Our Case Number: ABP-316119-23

Re: DART+ South West Electrified Heavy Railway Order - Hazelhatch & Celbridge Station to Heuston Station,
and Hesuton Station to Glasnevin
County Dublin and County Kildare

Observation: DART+ South West Electrified Railway Order 2023

Re.: Works Layout Plan No. 16, McKee Barracks Bridge (OB03) to Cabra Road Bridge (OB06)

Plan No. WORKS LAYOUT PLAN No. 16

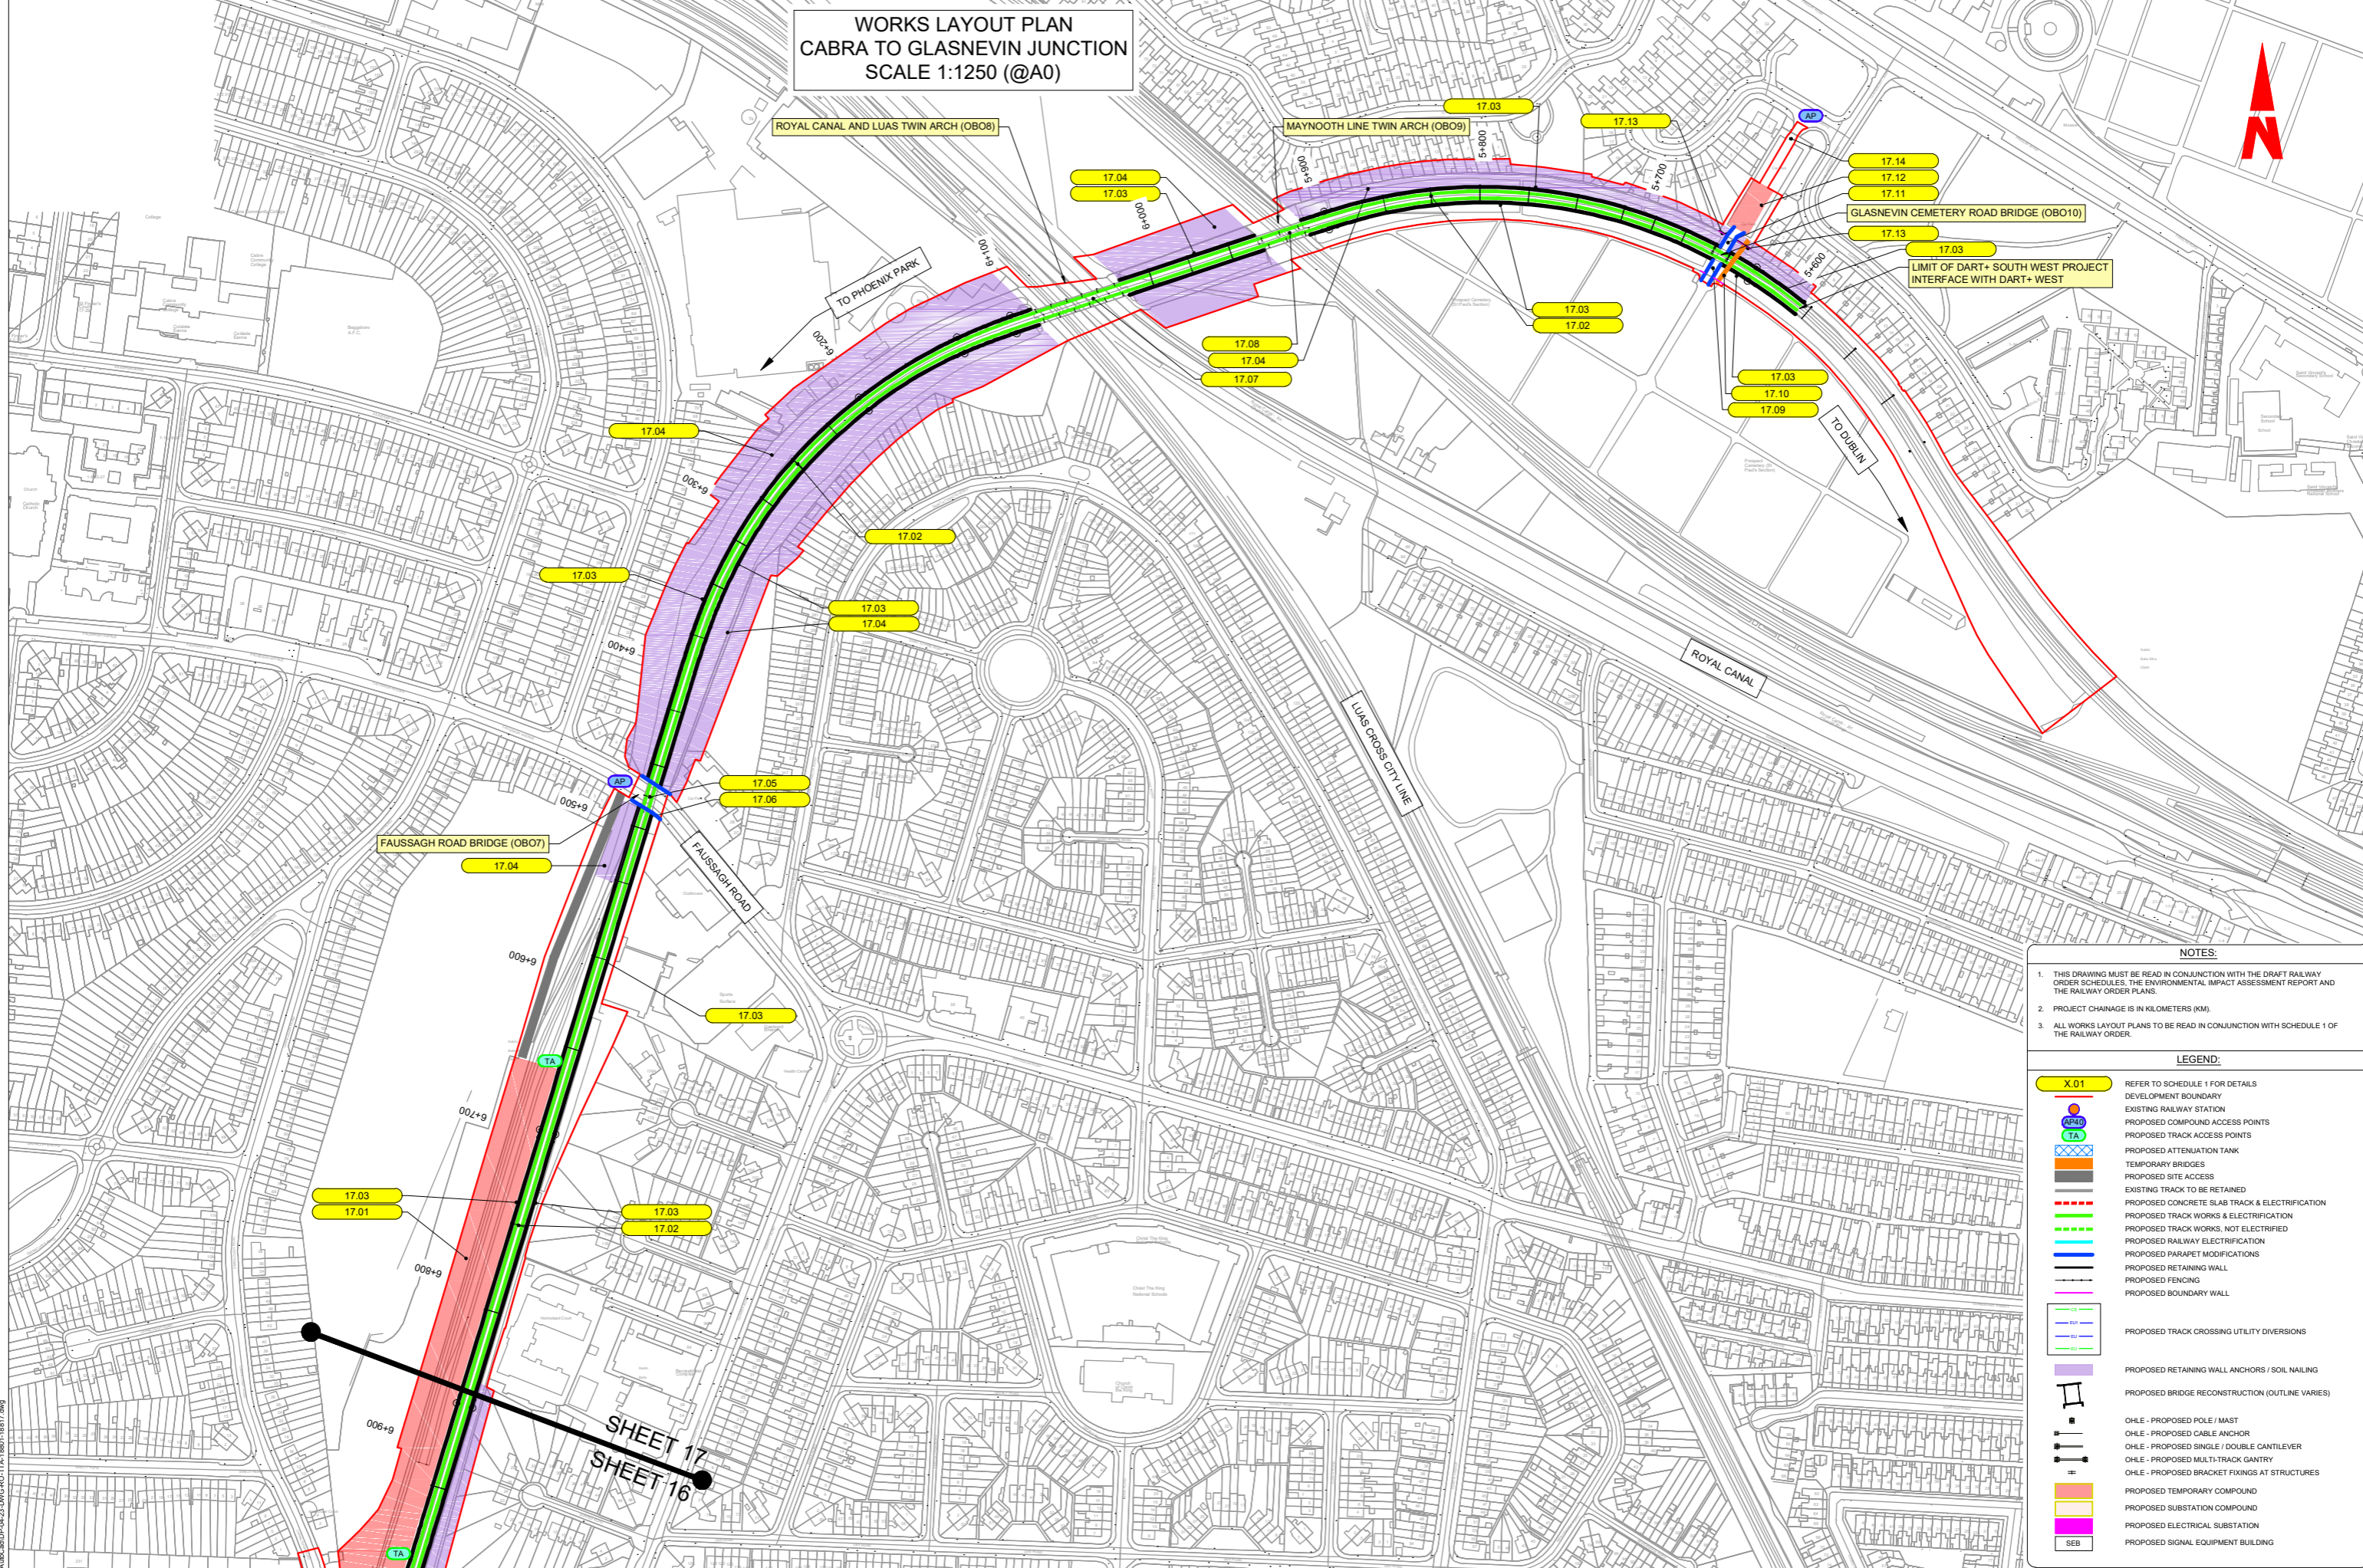
We, as a group of residents of Glenbeigh Road, are submitting an observation relating to the above-mentioned Dart+ South West Railway Order, pertaining specifically to Works No. 16.10 -

Construct a palisade fence on top of an existing low level masonry boundary wall. Works also include localised repairs to the existing boundary wall.

1. On alternatives to the proposed building of the palisade fencing and repairs to the boundary wall, as marked in Plan No. 16.
2. Could consideration be given, in consultation with residents, to an alternative placement of a barrier that would permit residents to retain access and enjoyment of this invaluable resource, Choice of boundary works materials to be permitted (e.g. greening/planting of beech hedging, willow or trees or alternative less harsh boundary treatment on the external boundary with the railway line and embankment)
